**Housing Strategy and Development Team
Housing Services
Planning Application Comments**

Planning Application Number: 21/02893/REM

Site Name: Os Parcel 4300 North Of Shortlands And South Of High Rock,
Hook Norton Road, Sibford Ferris

Objection: Issues with the proposed layout

Design Proposal | Site Access and General Arrangement Plan

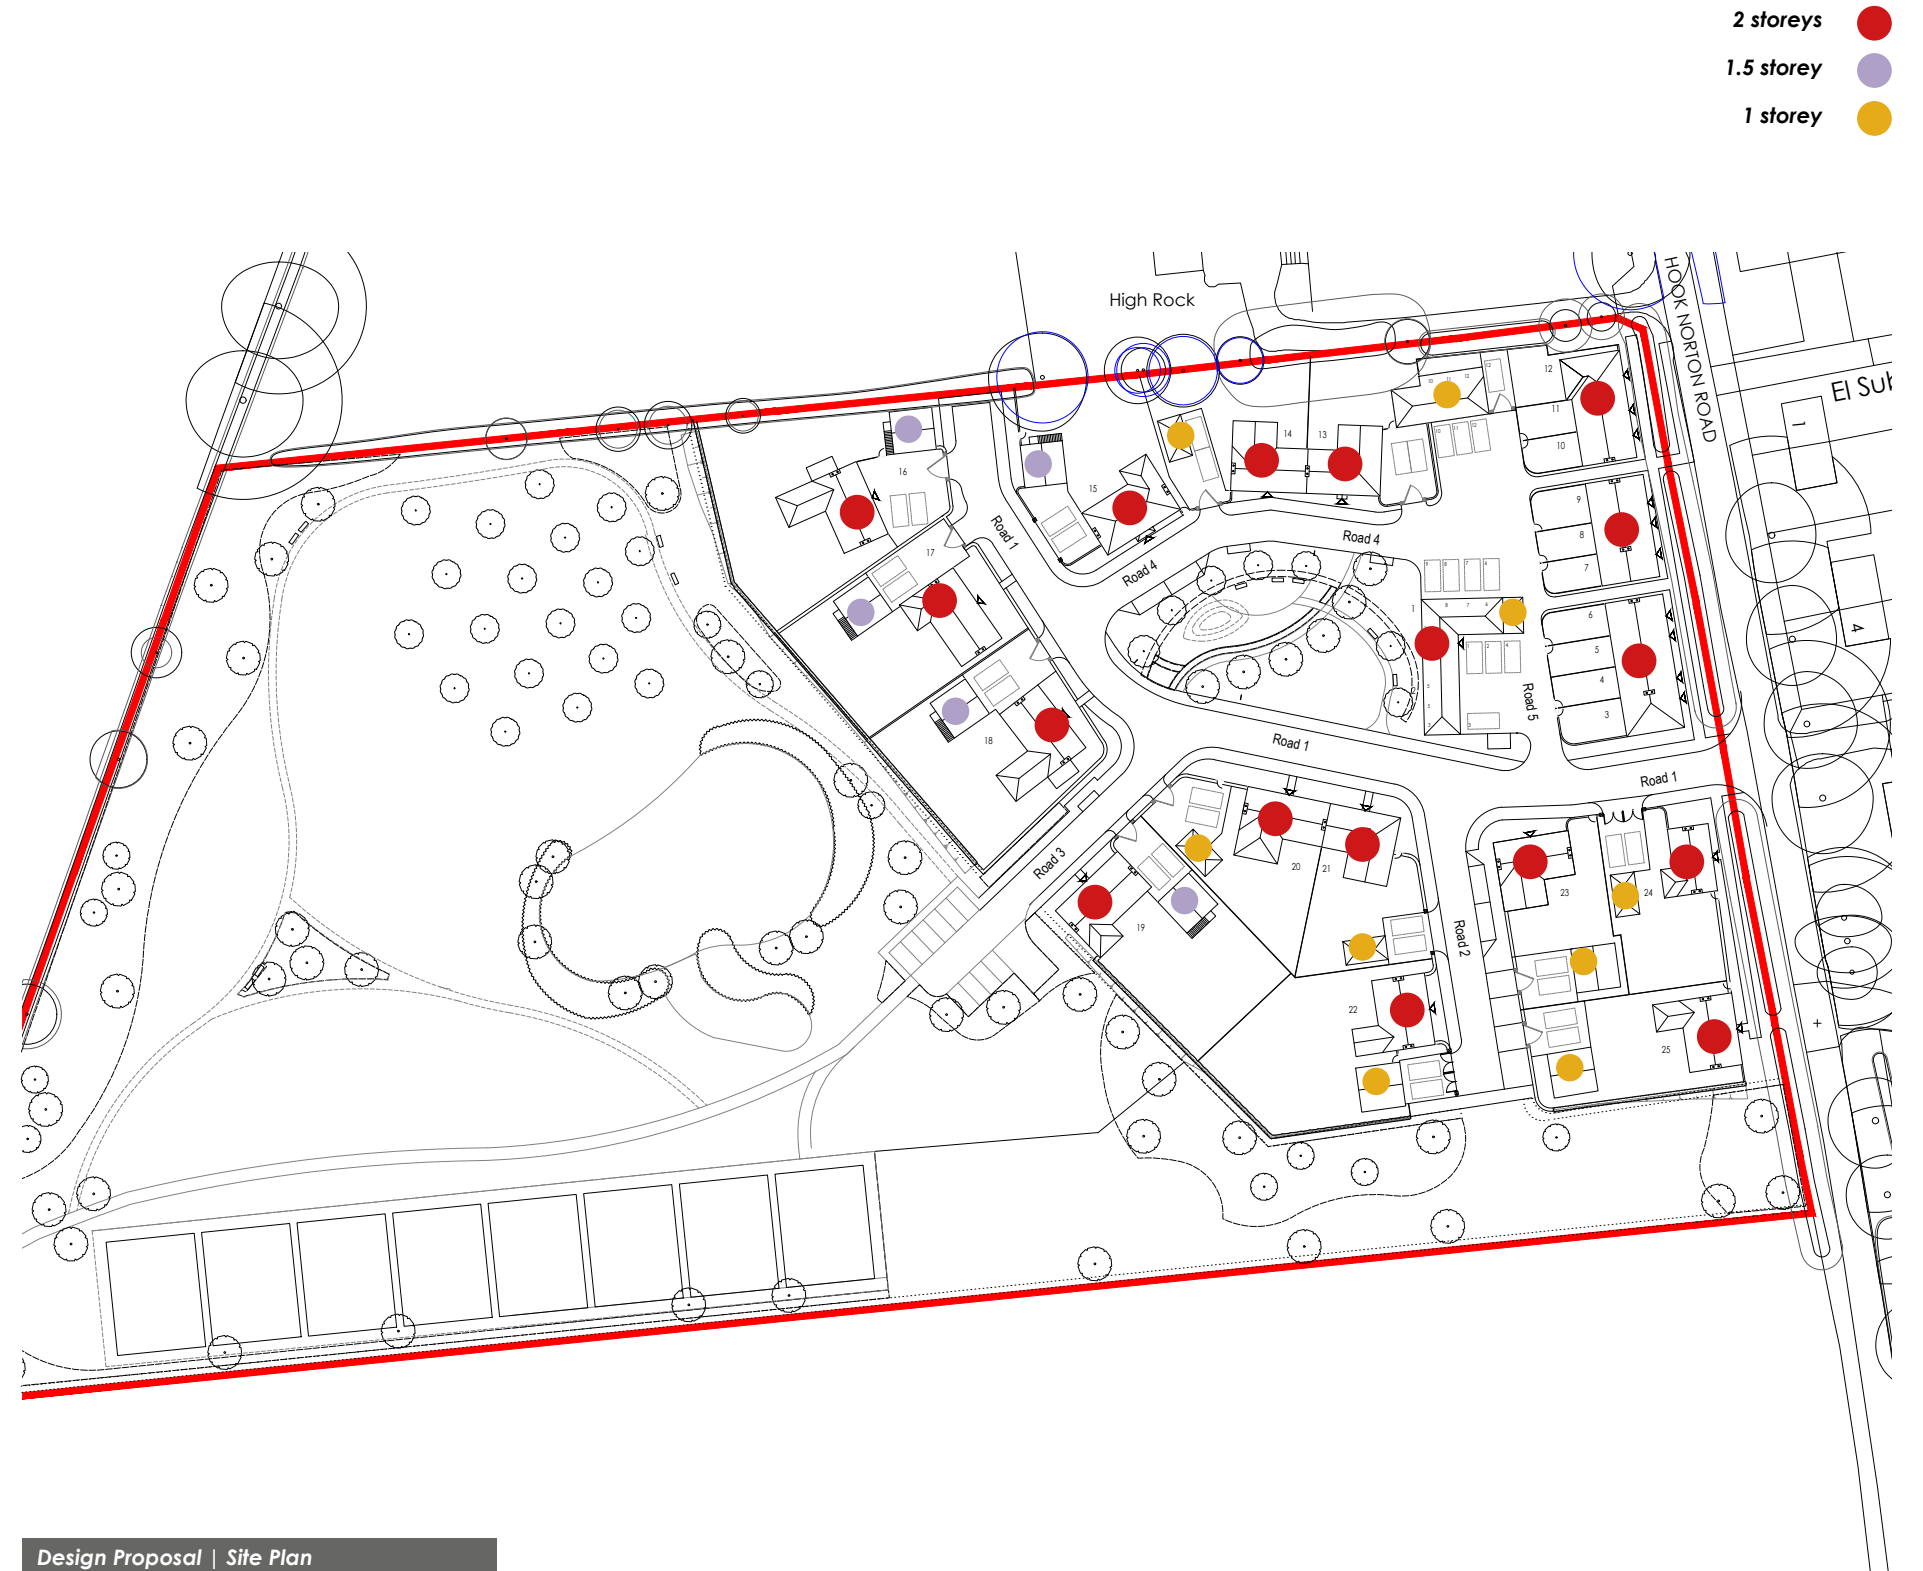
The proposed layout deviates from the outline application layout which Planning Officers requested that the applicant adheres to. The affordable dwellings in the outline layout are at right angles to each other and although the gardens are smaller, this layout is preferable to the proposed layout.

1. As mentioned in point (ii), plots 1 and 2 are flats above garages rather than 1-bed 2-person houses as required in the S106. The building is therefore elongated and takes up the whole length of plots 3,4, 5 and 6. This means that this 2-storey, elongated building will dominate the rear of these family-sized dwellings and will obscure their view of the amenity space in the centre of the development. Even if they were designed as 1-bed houses in compliance with the S106 they would still obscure the view from some of the above-mentioned plots. Whilst there are rear gardens for children to play in, the prospective tenants will not have the same opportunity as other residents to watch their children play safely in the designated area in the centre. We appreciate that it is necessary to provide adequate parking spaces, however it is not acceptable for these to be provided in this way as it will make this section of the development extremely cramped.

2. The building containing plots 1 and 2 is situated in very close proximity to plots 3, 4, 5 and 6, creating a very cramped arrangement. It is not clear from the plans whether the space in between the buildings is intended to be a highway, if so then it is doubtful as to whether emergency vehicles would be able to get through.

4. The size of the market plots in comparison to the affordable plots and the fact that many of the market dwellings are gated also clearly distinguishes them from the affordable dwellings

1. A review of the design and layout of the site to ensure that the affordable dwellings blend in with the market dwellings, have adequate external space and that the occupants will have equal

2. Following on from point 1, a review of the parking provision for plots 1, 2, 3, 4, 5 and 6. Discussions with Cherwell DC Planning and/or Strategic Officers may be beneficial.
3. The provision of plans showing details of how M4(2) requirements will be met
4. Planning conditions placed on plots 1,2, 3, 4, 5 and 6 in respect of point 3.
